CITY OF ALBUQUERQUE

December 5, 2012

**Re: 900 Griegos Road Townhomes Grading and Drainage Plan
Engineer's Stamp date 11-26-12 (F-14/D067)**

ENGINEER'S SEAL DAVID SOULE P.E. #14522	900 GRIEGOS ROAD TOWNHOUSE PROJECT	DRAWN BY WCUJ
	GRADING AND DRAINAGE PLAN	DATE 11-15-12
	 1606 CENTRAL AVENUE SUITE 201 ALBUQUERQUE, NM 87106 (505) 872-0899	SHEET # — JOB # 21258

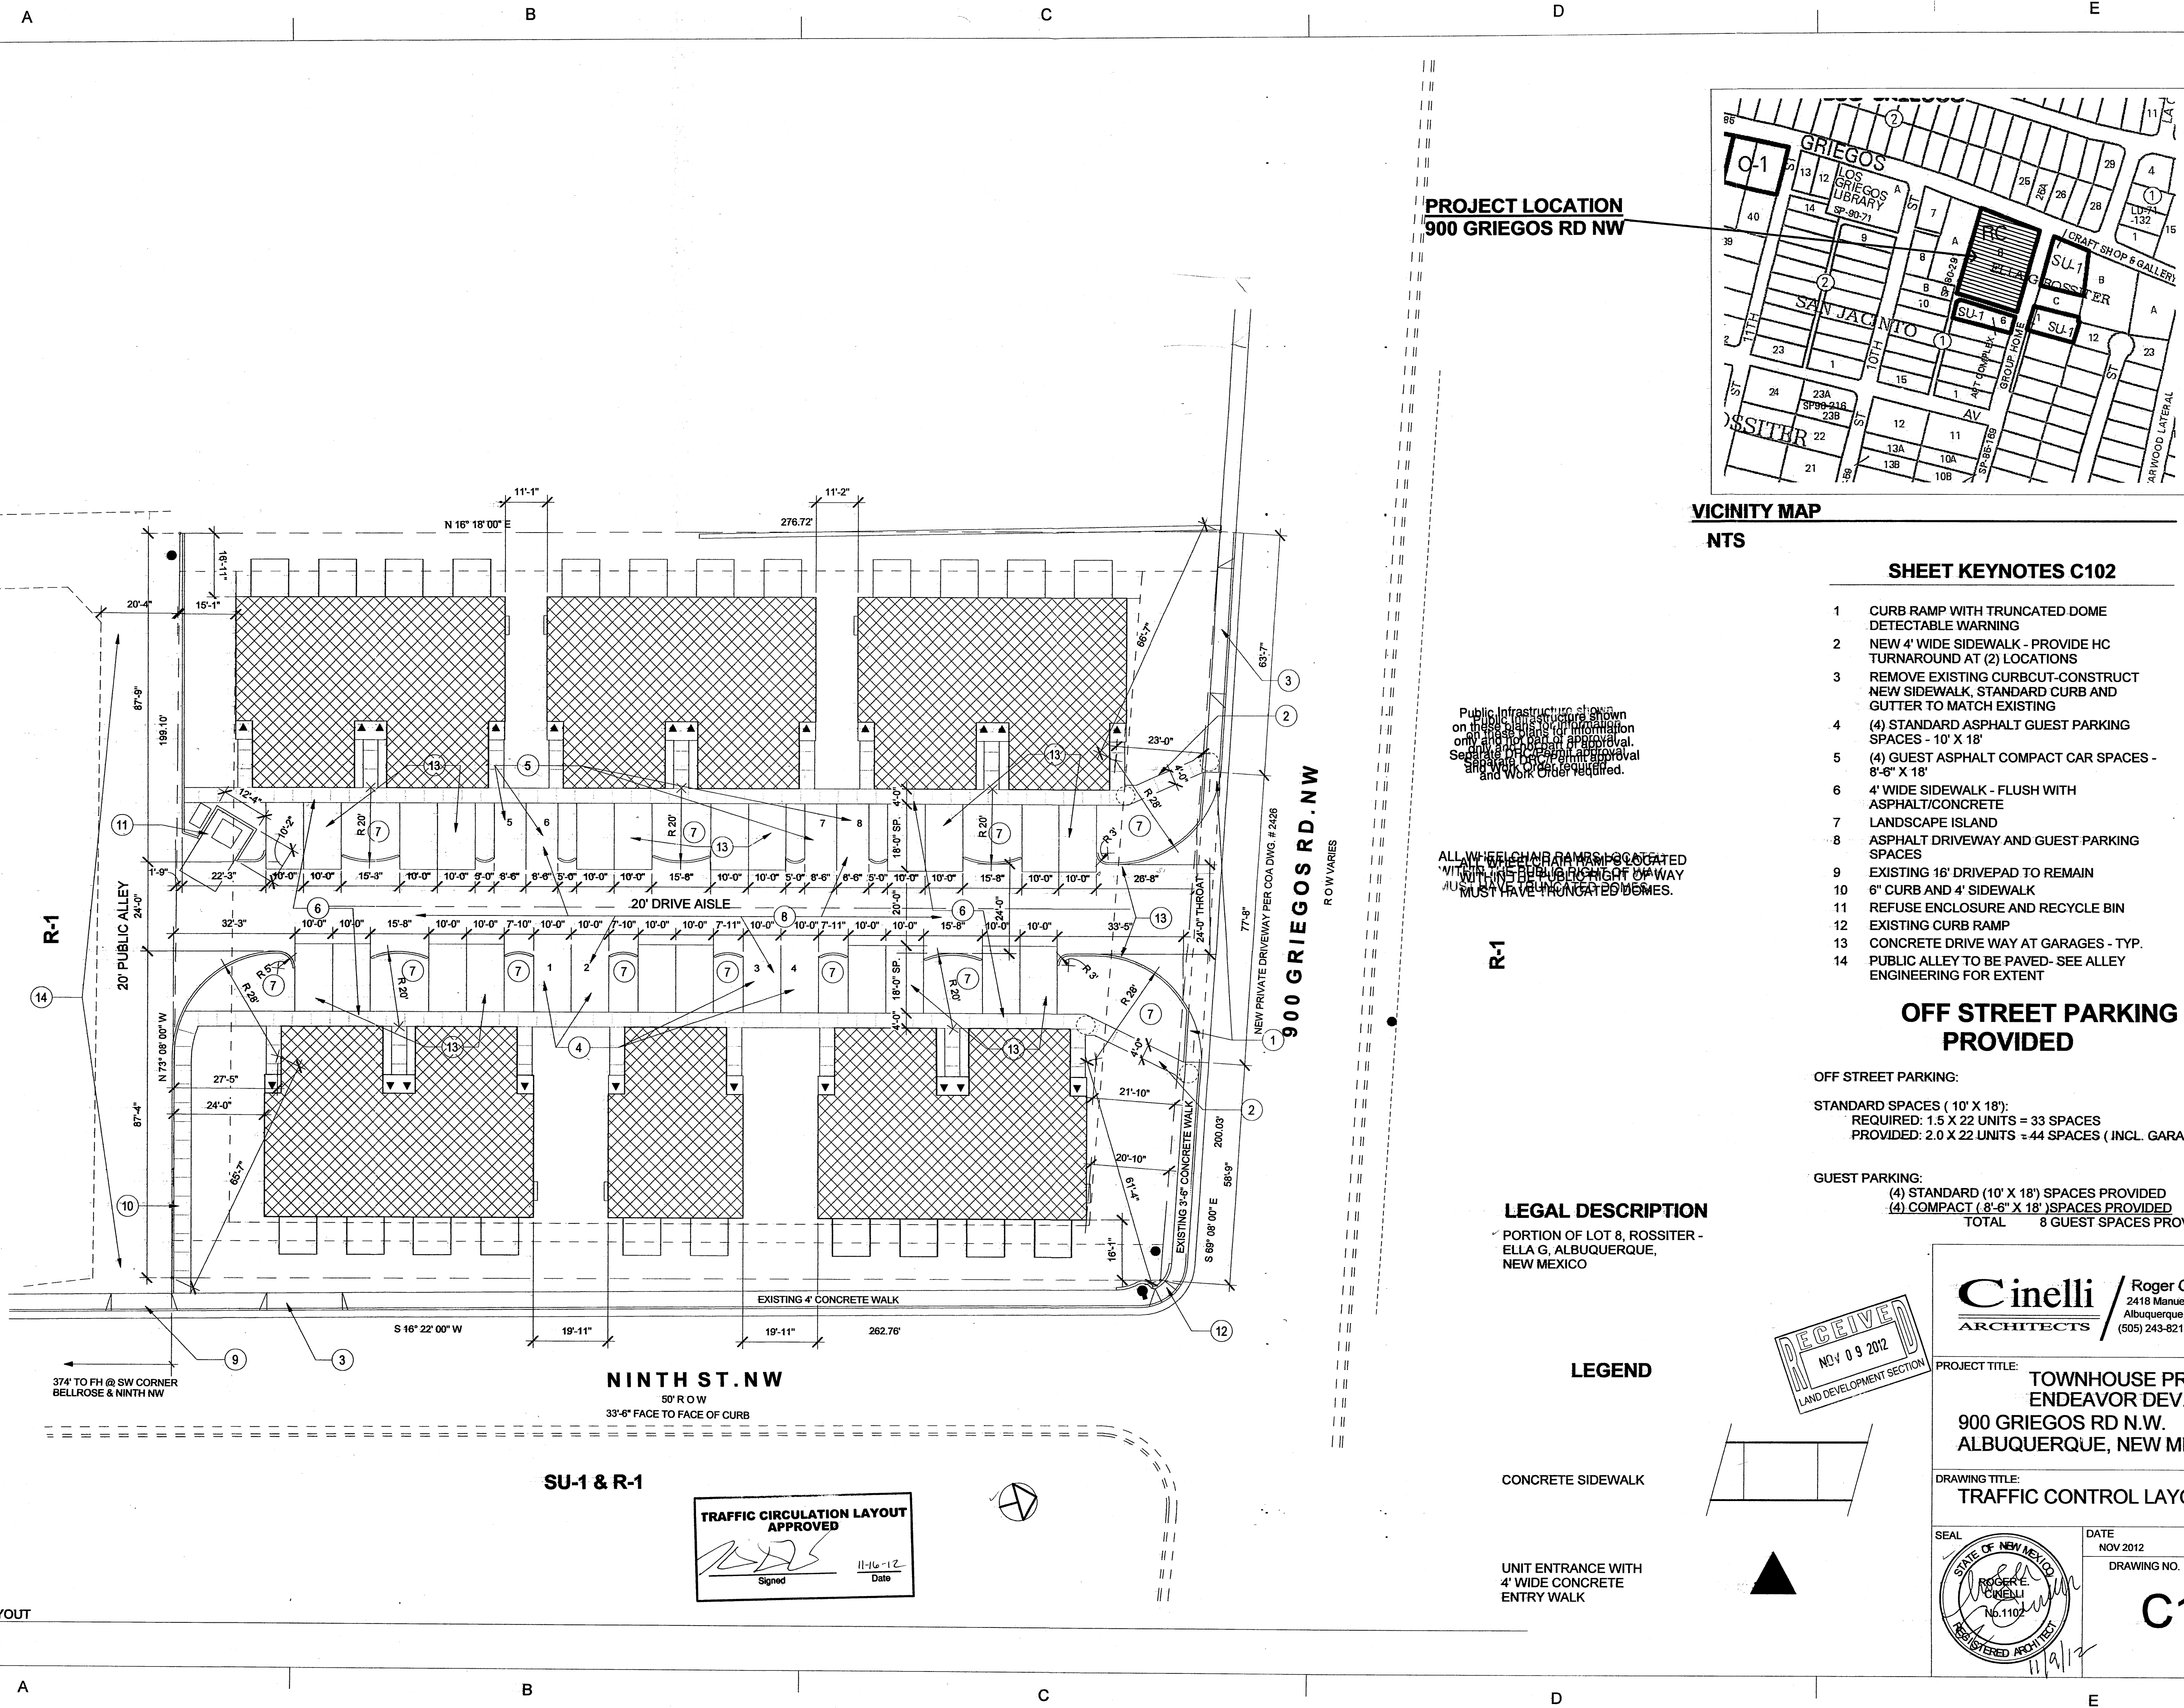
- Please show direction of roof drainage and any wall openings that will be utilized to pass flow through the property.
- Indicate on the plan the outfalls for each sub-basin and simplify if possible.
- Show the overflows for each of the proposed ponds.
- The public alleyway should be graded to drain the entire alley to 9th Street.
- New development will be limited to a discharge of 2.75 cfs/acre.
- Additional spot elevations for the property to the west of the site need to be provided. Quantify any offsite flows being received from this area.
- Top-of-curb elevations need to be provided along 9th Street.
- Include a legible FIRM map on the plan set as well as a benchmark designation.
- What is being represented along the northwest property line? What is being depicted by the symbol on the eastern edge of the northeastern pond?
